# A303 Sparkford to Ilchester Dualling Scheme TR010036

## 9.2 Environmental Statement Table of Errata

**Environmental Statement Table of Errata**

<b>Regulation Number:</b>	
<b>Planning Inspectorate Scheme Reference</b>	TR010036
<b>Application Document Reference</b>	9.2
<b>Author:</b>	A303 Sparkford to Ilchester Dualling Scheme Project Team, Highways England

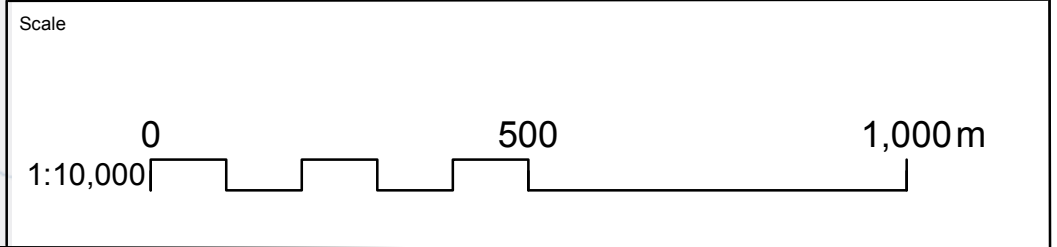
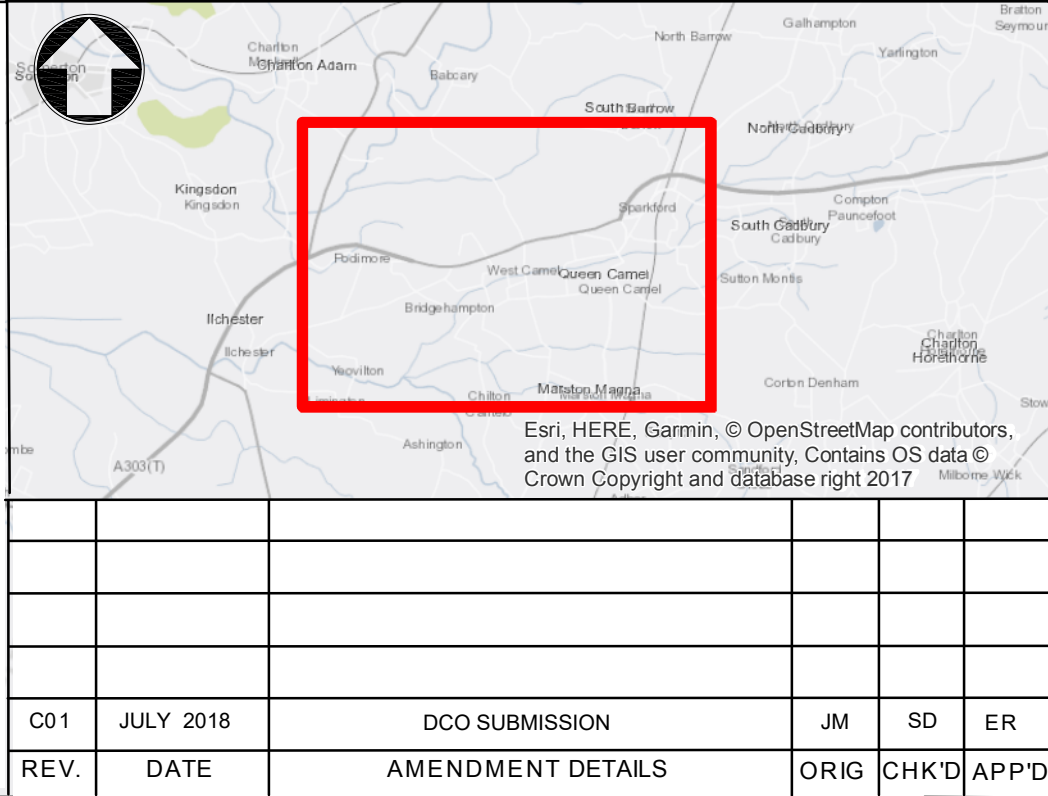
1.4.11	Volume 6.1 Environmental Statement Chapter 11 Noise and Vibration (APP-044)	22 - 23	The operational study area depicted in Figure 11.1 in Chapter 11 of the ES (APP-048) is inconsistent with the operational study area described in Chapter 11 section 11.6. Can this be rectified please?	Amended in response to ExA question 1.4.11. Referred to the wrong appendix figures in paragraphs 11.6.1 and 11.6.2.	Paragraphs 11.6.1 and 11.6.2 of Environmental Statement Chapter 11 Noise and Vibration (APP-048) are amended to:  <i>"The assessment area for temporary noise and vibration impacts during construction is 300 metres from construction activity (seen in Figure</i>

Reference	Document number	Page no	ExA Written Question	Reason for amendment to the Environmental Statement	Amendment to the Environmental Statement
					<p><i>11.42 Construction Noise Study Area, Volume 6.2) due to the nature of the noise sources, the typical distances from source to receptor, and professional experience for the likely area of potential adverse effects from similar highways construction assessments."</i></p> <p><i>"HD213/11 provides the methodology for assessment of road projects within the UK. The methodology, which has been applied for the purposes of this assessment, requires that the study area is identified as an area within 1 kilometre of the physical works associated with the scheme. Within this study area, road traffic noise calculations are performed at any sensitive receptor within 600 metres of a road where there is a possibility of a change of 1dB LA10,18hr upon scheme opening, or 3dB LA10,18hr in the long term. The operational noise calculation area is shown in Figure 11.21 Operational Noise Study Area, Volume 6.2."</i></p>
